**Our ref:** NO/2021/113750/06-L01  
**Your ref:** 3/2021/0731  
**Date:** 05 October 2023

**REDEVELOPMENT OF THE EXISTING EDUCATIONAL FACILITY INCLUDING PART DEMOLITION OF THE EXISTING INFANT SCHOOL TO PROVIDE A STANDALONE NURSERY FACILITY, TOGETHER WITH THE ERECTION OF A NEW INFANT BLOCK TO THE REAR OF THE NEW NURSERY BUILDING, ALONGSIDE ADDITIONAL CAR PARKING. SOFT AND HARD LANDSCAPING TREATMENT AND VEHICULAR AND PEDESTRIAN ACCESS WORKS OFF GREENACRE STREET. ST. JAMES' C OF E PRIMARY SCHOOL, GREENACRE STREET, CLITHEROE, BB7 1ED**

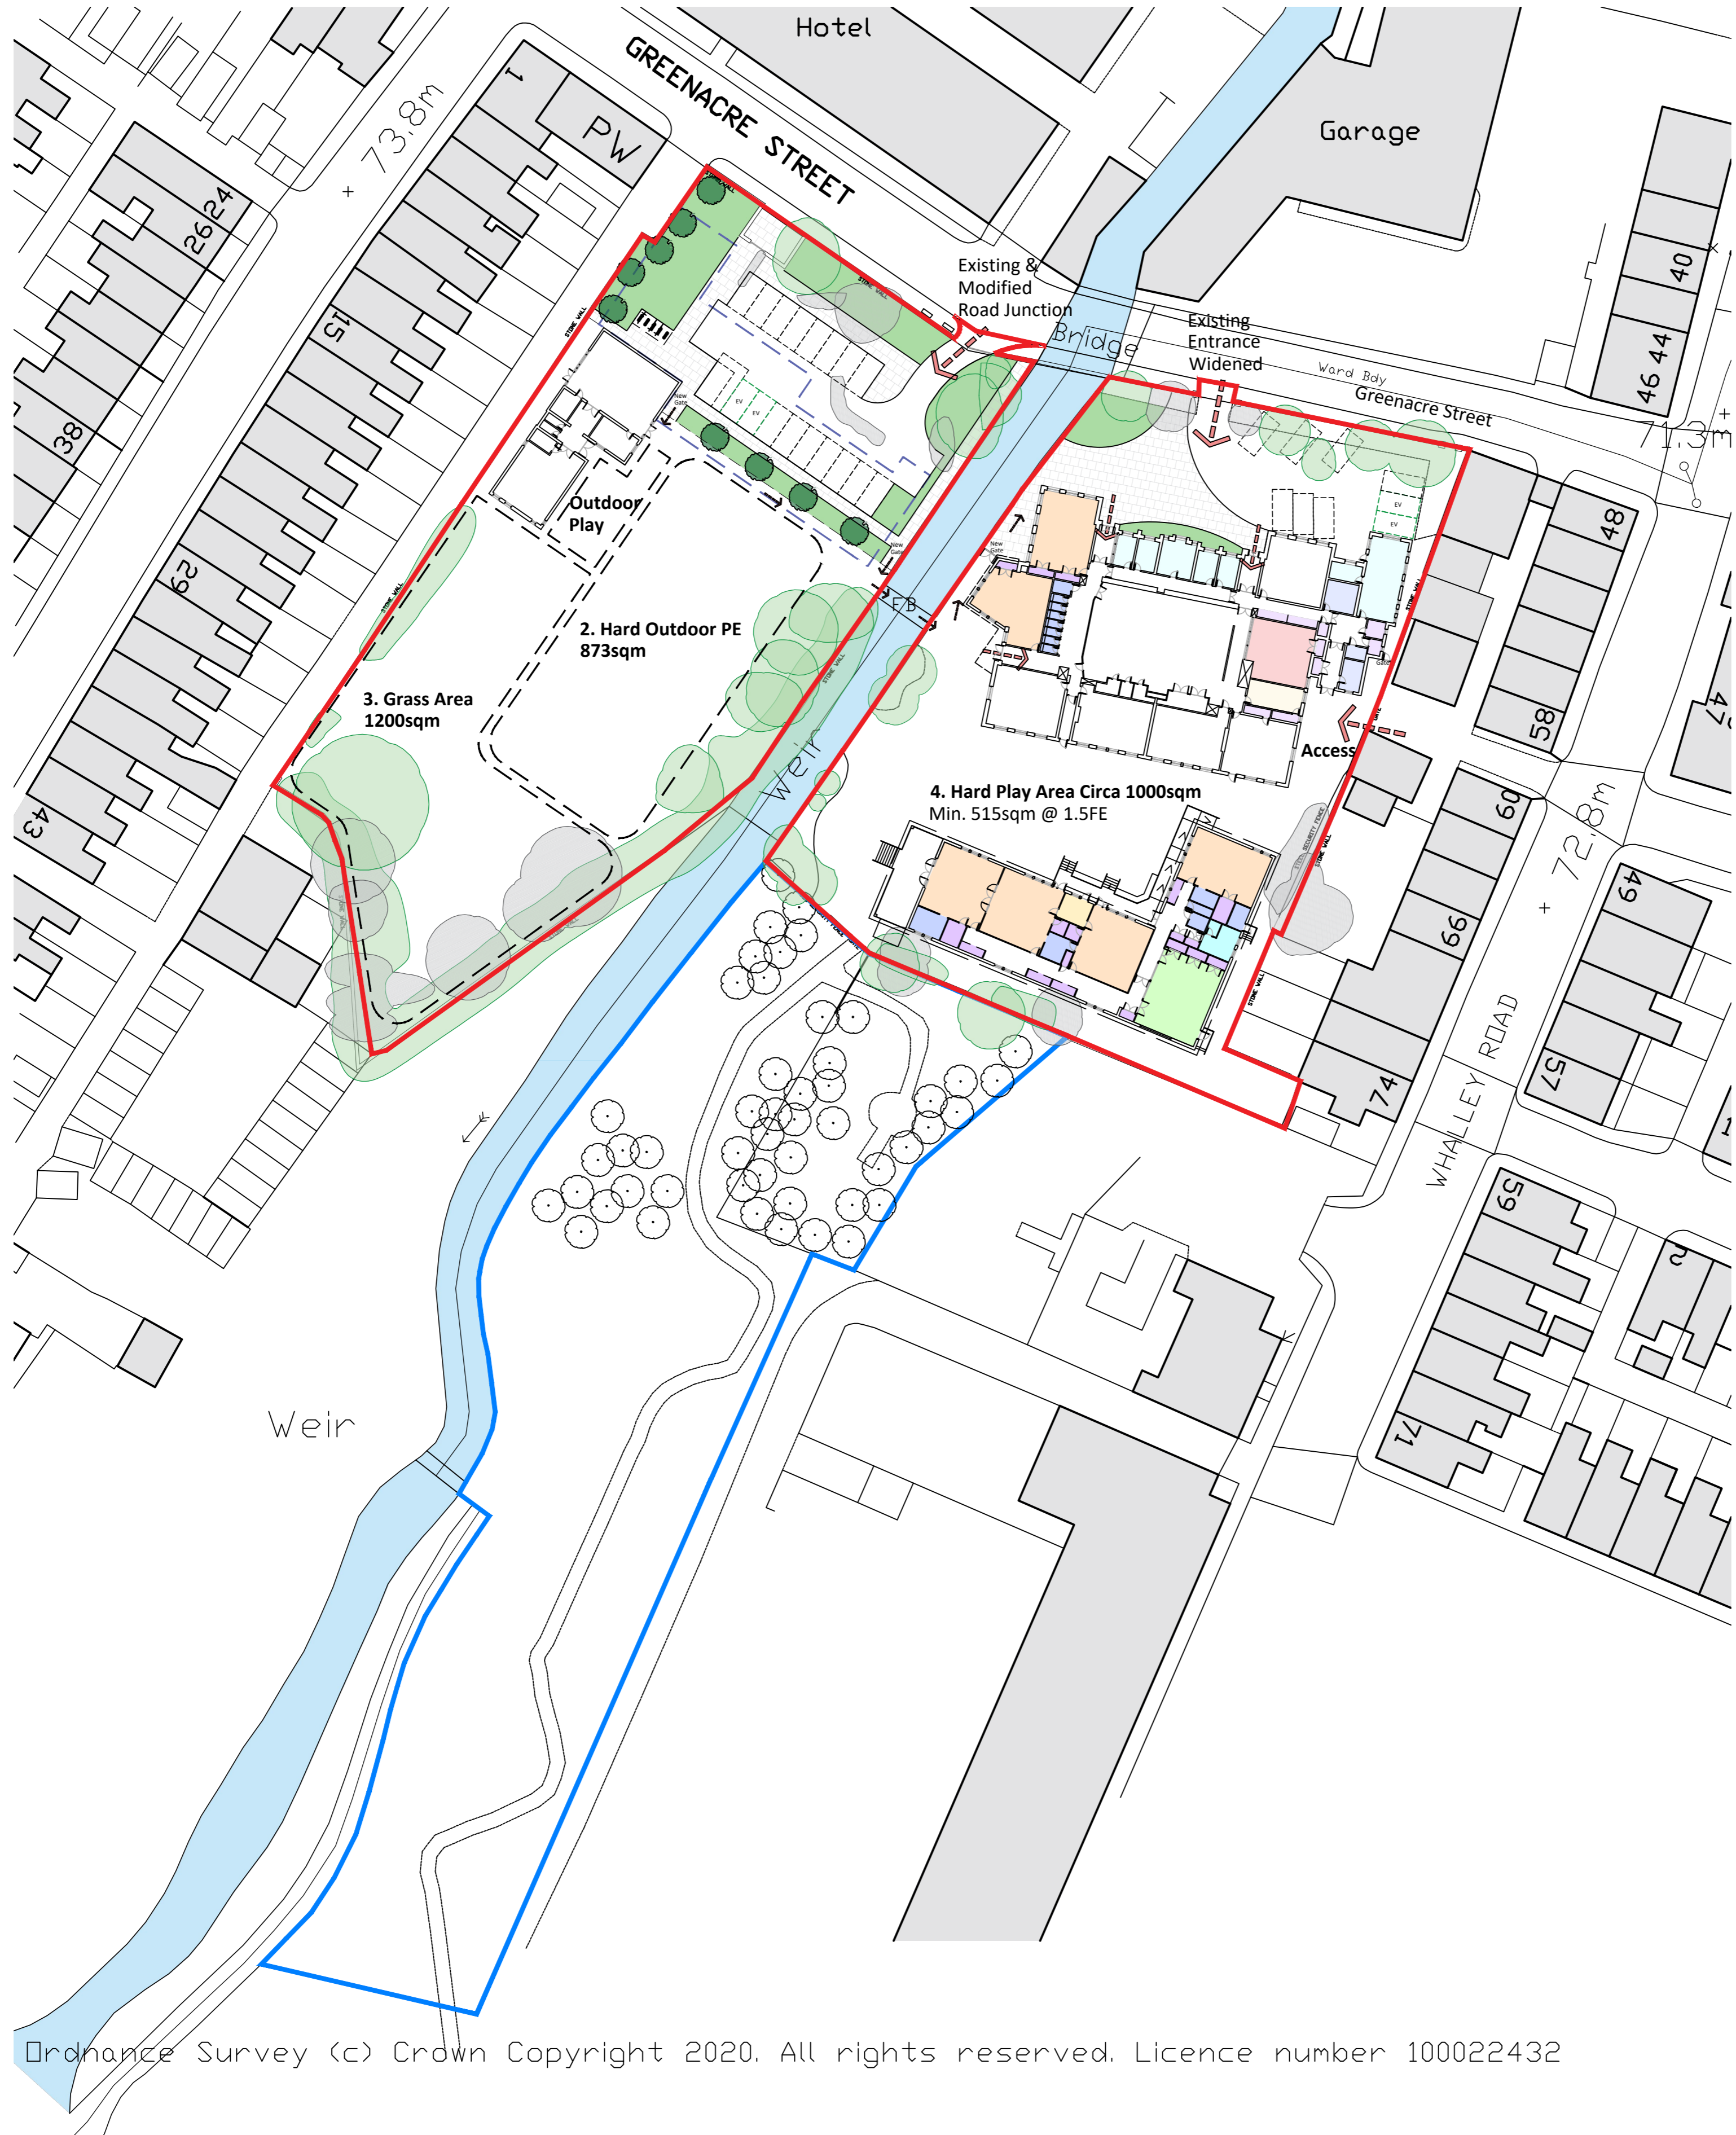
An area for proposed compensatory storage area comprising of 120m<sup>2</sup> is suggested in the FRA and indicated in the proposed site plan STJ-CAA-ZZ-DR-A-1002 Rev P1. However, this detail is not yet designed and therefore we have no objection to the proposal subject to the inclusion of the following planning condition:

The development hereby permitted must not be commenced until such time as a scheme to provide appropriate compensatory storage on site has been submitted to, and approved in writing by, the local planning authority.

- The scheme and plans submitted shall show the final engineering solution for the compensatory storage, providing detailed design to demonstrate how the scheme will function to ensure flood waters can enter the storage and be discharged freely after a flood. It must be demonstrated that there will be no loss in storage capacity for the lifetime of the development.
- The scheme shall be fully implemented prior to any development on site and subsequently maintained, in accordance with the scheme's timing/phasing arrangements, or within any other period as may subsequently be agreed, in writing, by the local planning authority.
